Your ref: N6/2010/2055/MA

**BROADWATER ROAD WEST
ENVIRONMENTAL IMPACT ASSESSMENT
VISUAL AMENITY AND ARCHITECTURE**

BROADWATER RD WEST, WELWYN GARDEN CITY
 DETAILED PROPOSALS: RESIDENTIAL BUILDING K
 BAYSTUDIES NORTH AND SOUTH ELEVATIONS: PROPOSED
 568_07_325
 SCALE: 1:50 @A0 1:100 @A2

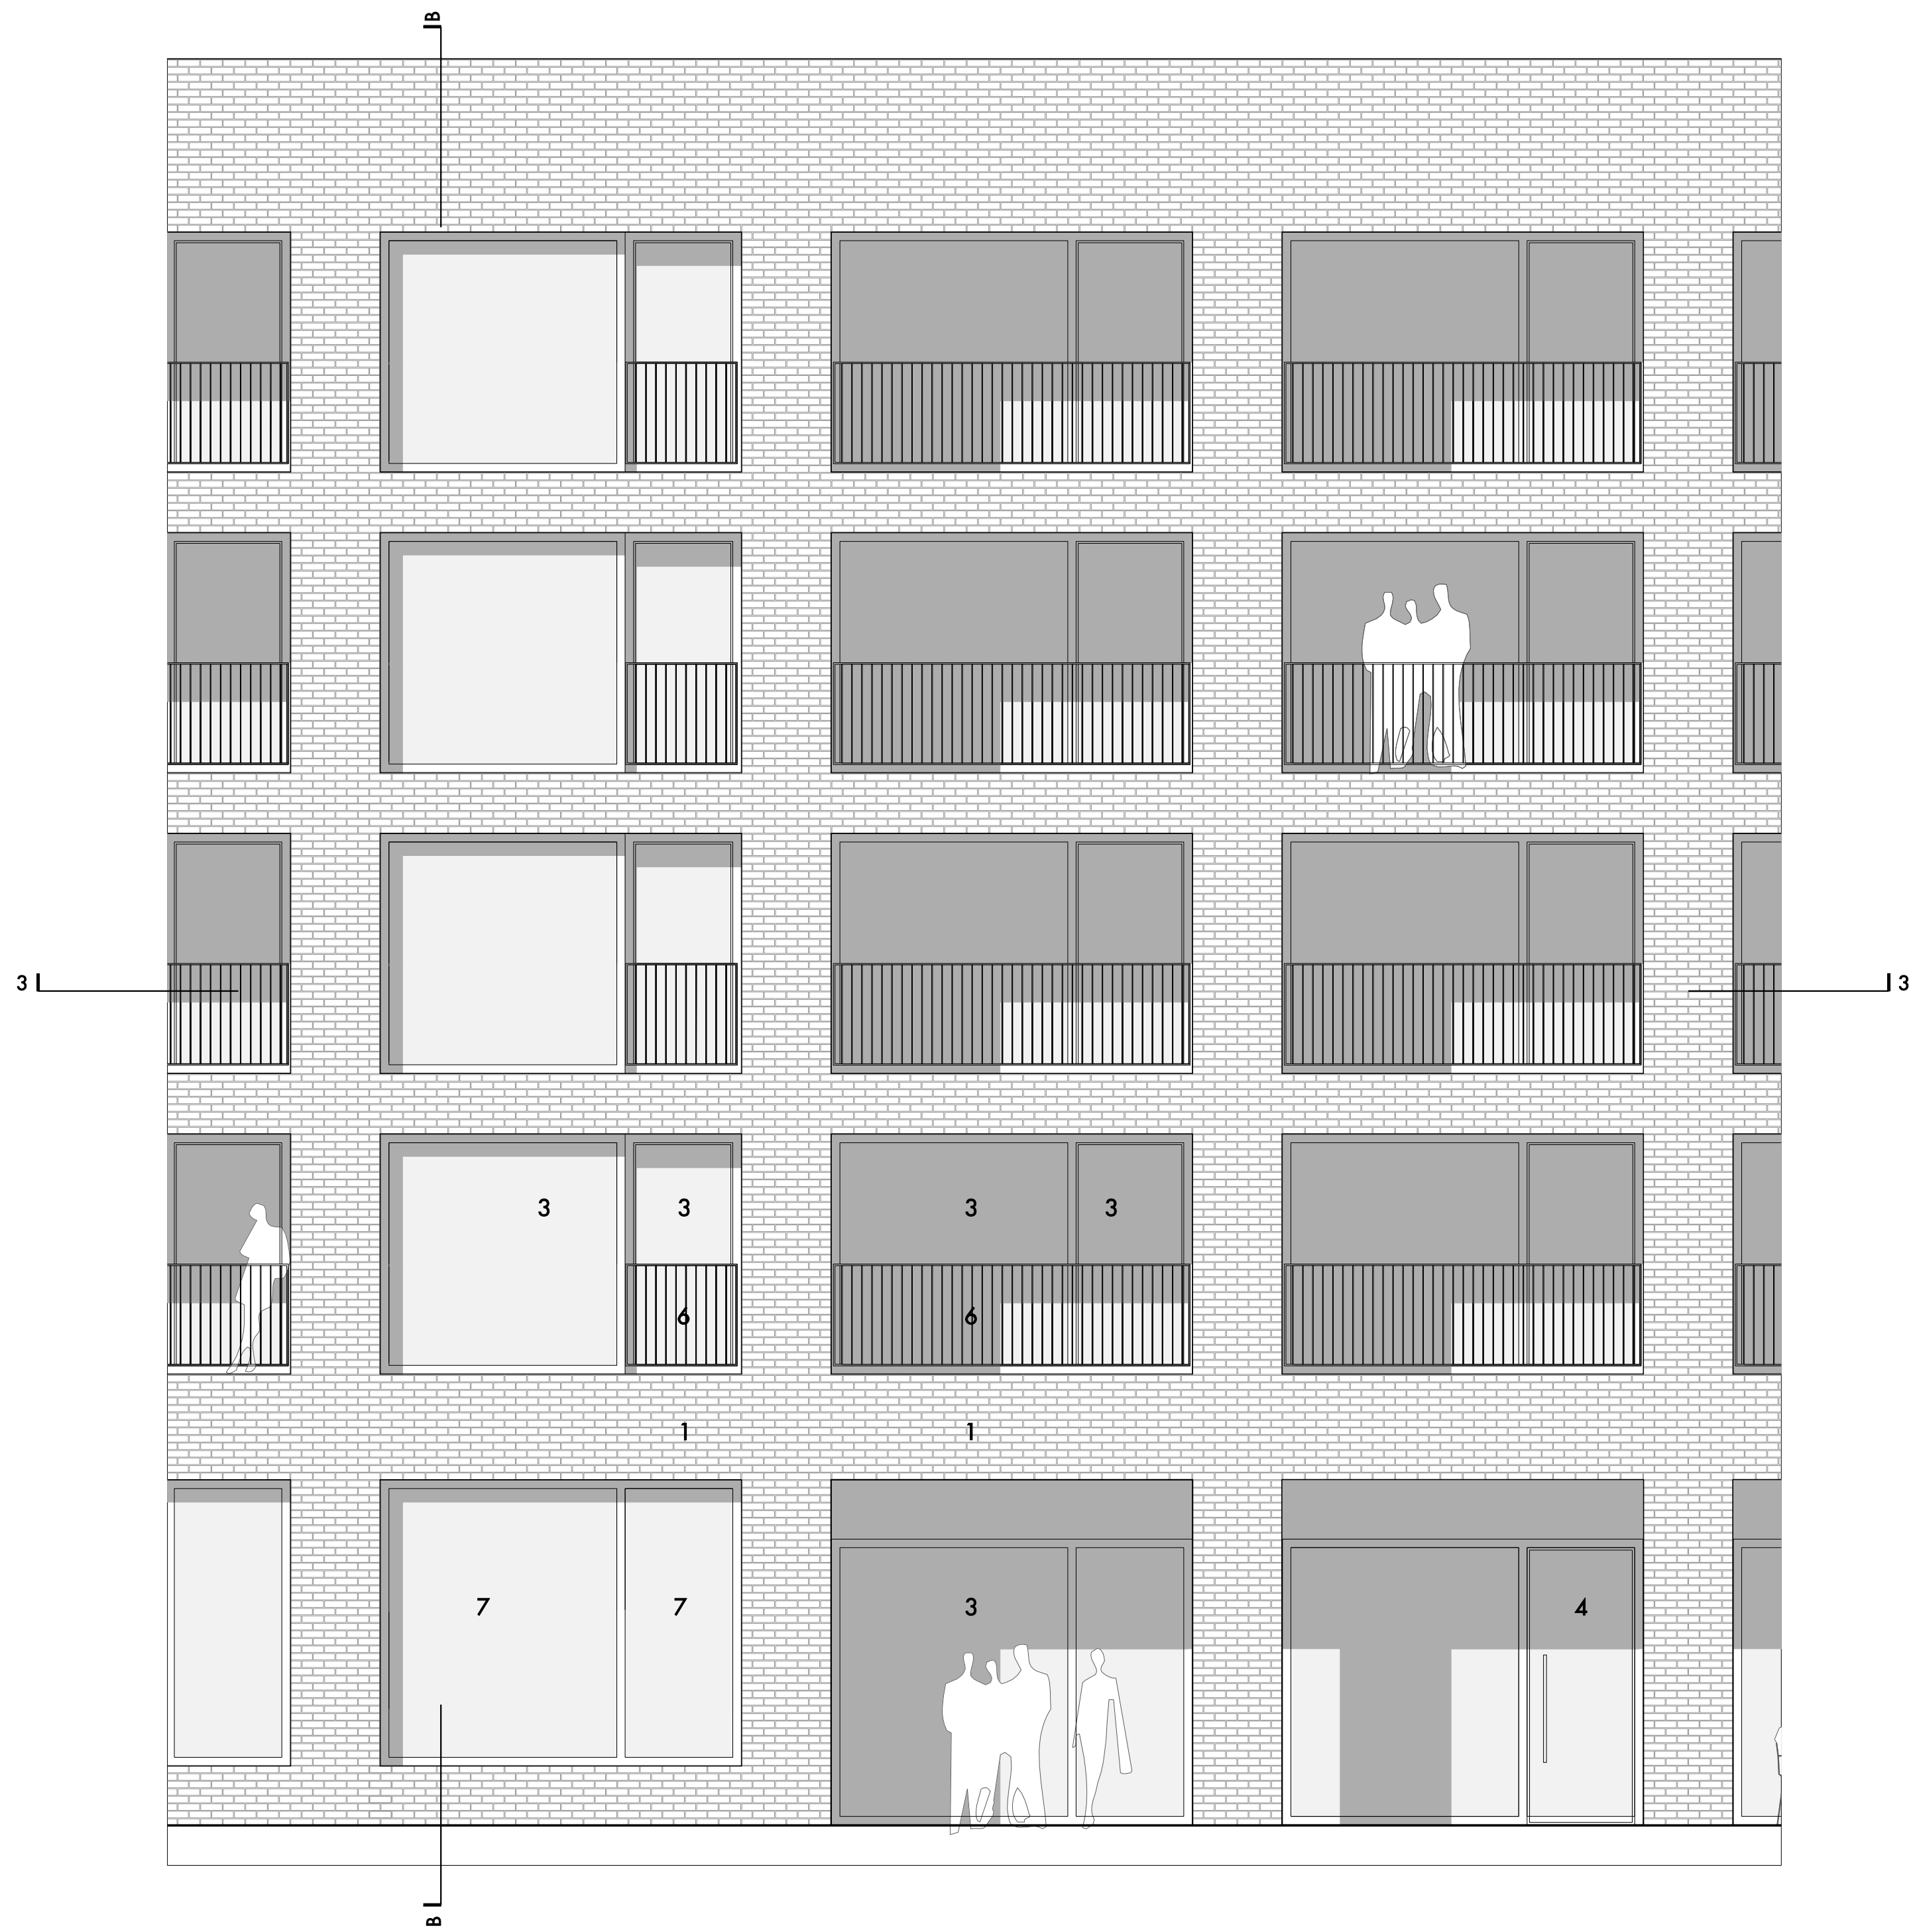
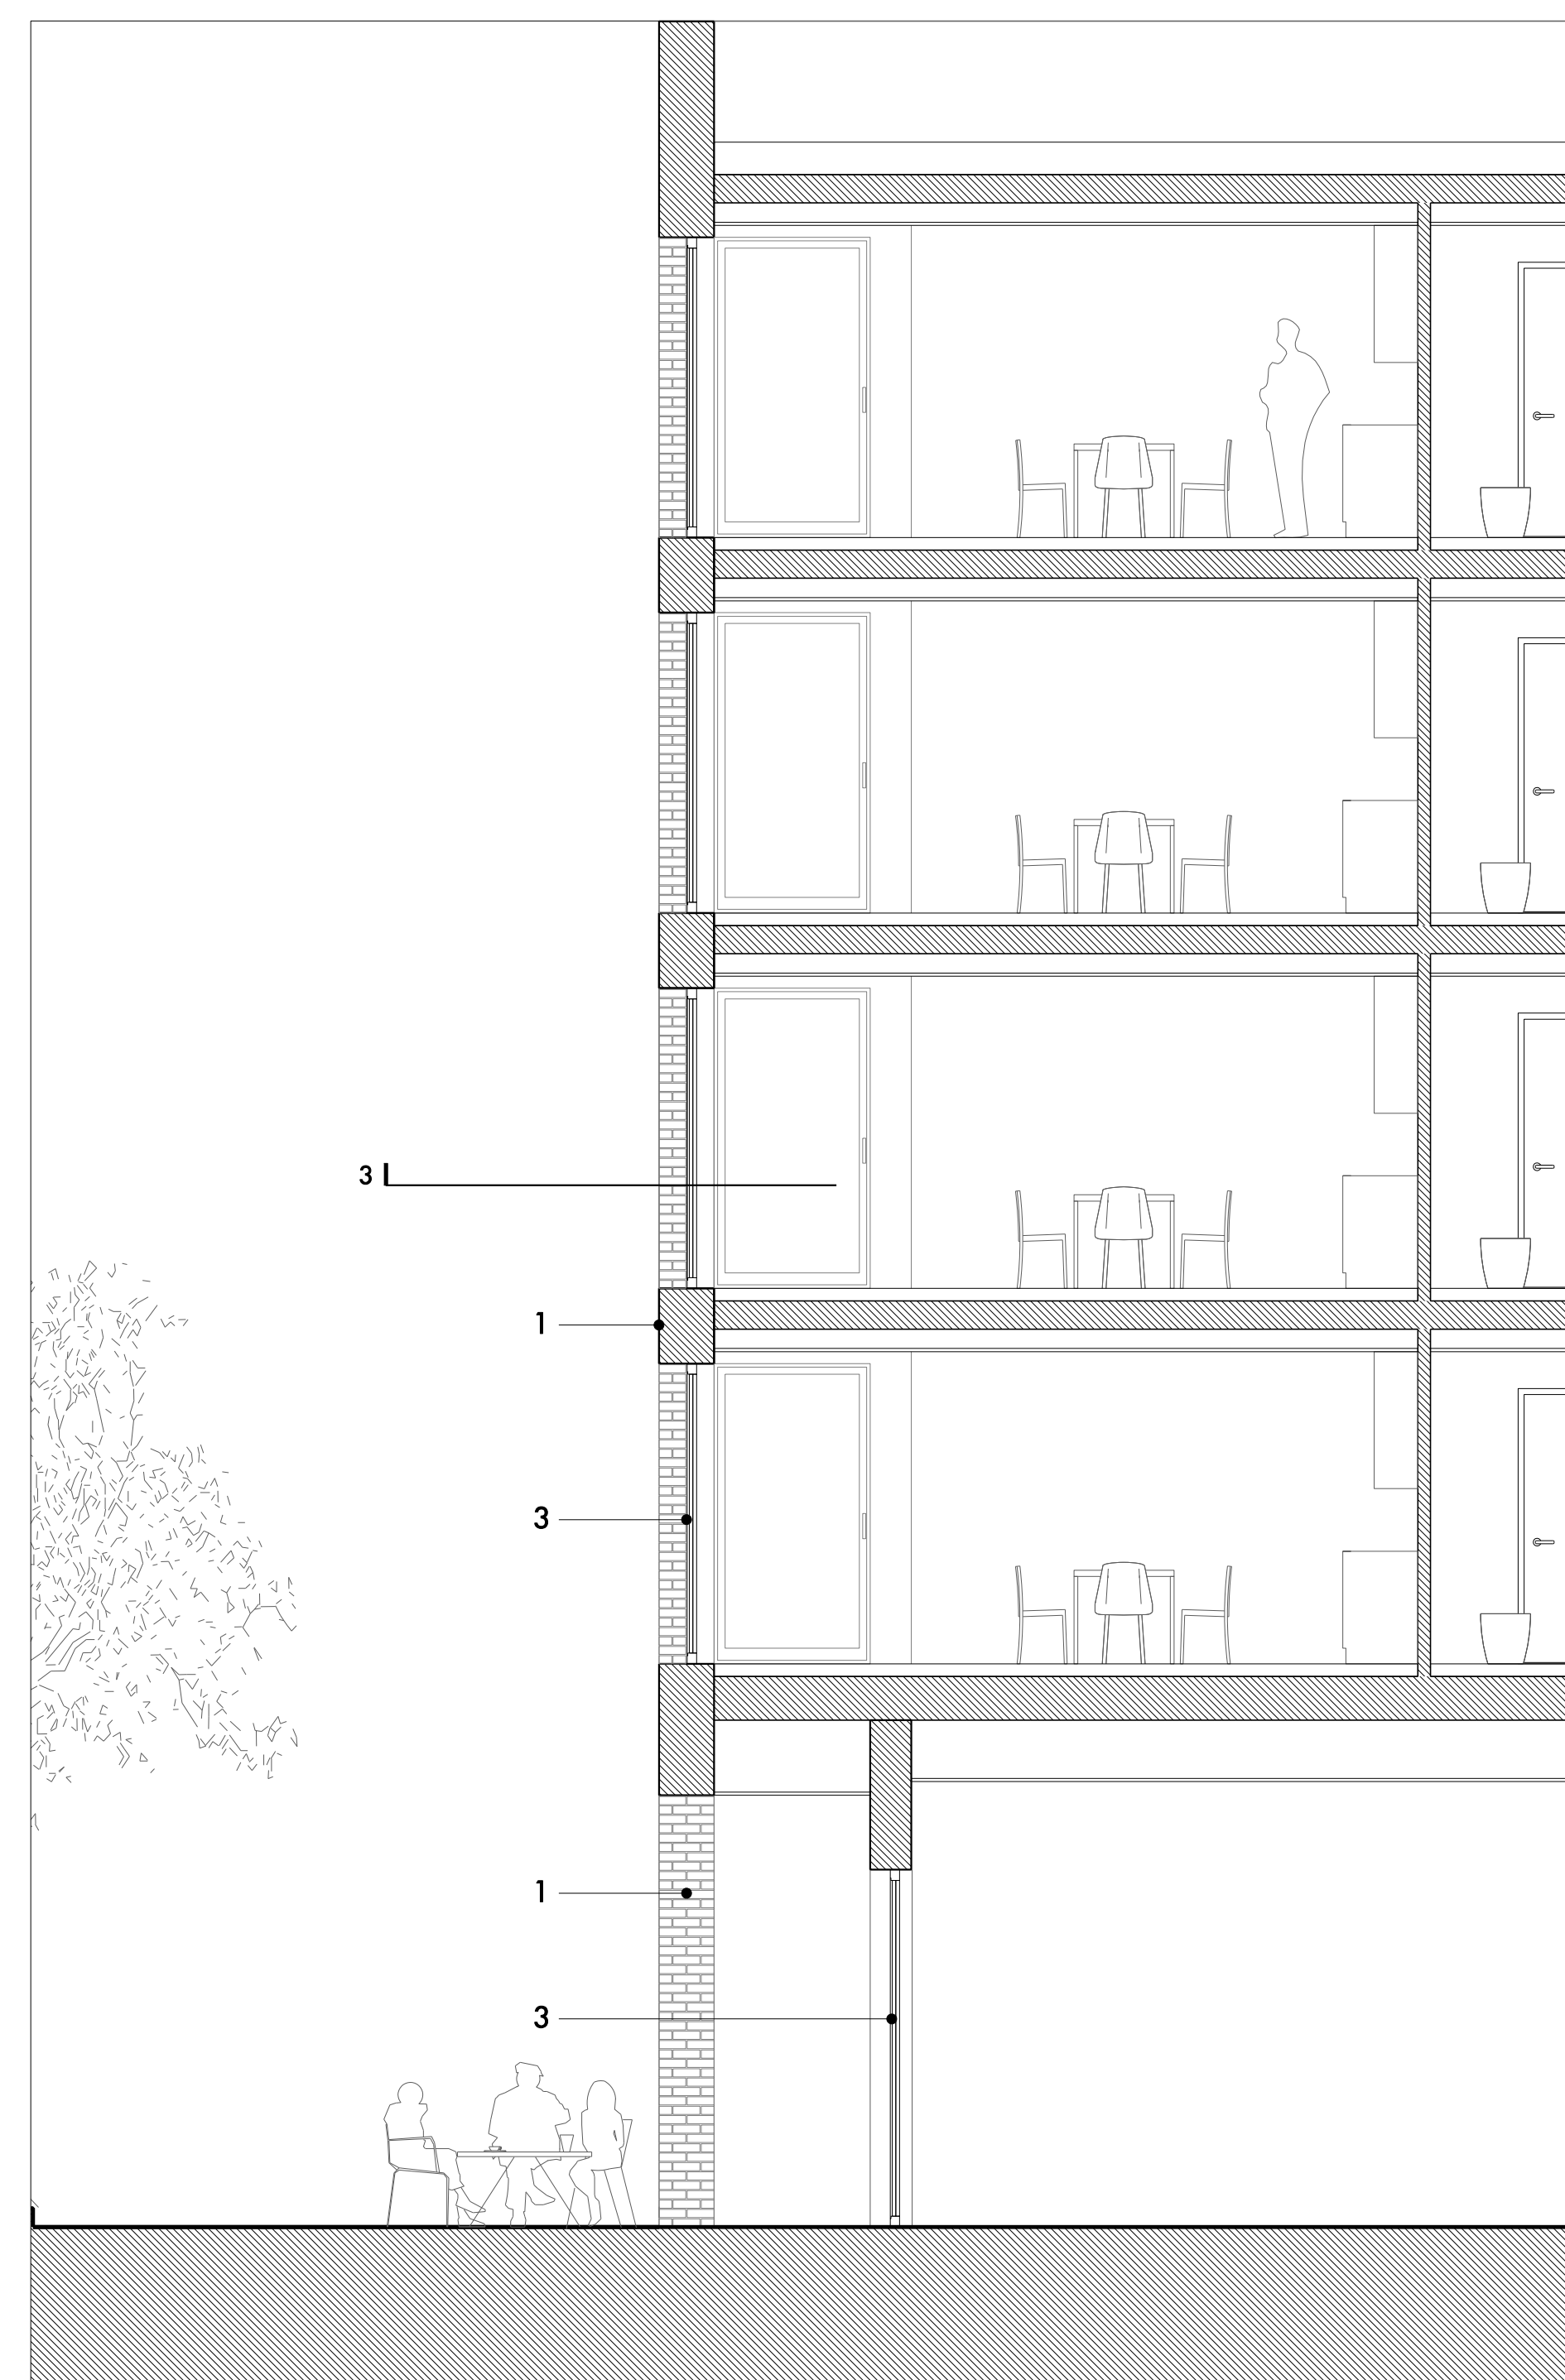
In spite of its title, this document makes little reference to architectural style and appearance. Such elevations as are shown, of commercial, community and residential buildings, are banal in the extreme. I assume they are just diagrammatic. Far more detail is required, and the Council would need to approve the final designs. Some recent WGC housing is disappointingly mundane. With a shortage of internal architectural staff, I suggest that the Council needs an independent (RIBA?) design review panel to advise on design quality and ensure the high standard promised.
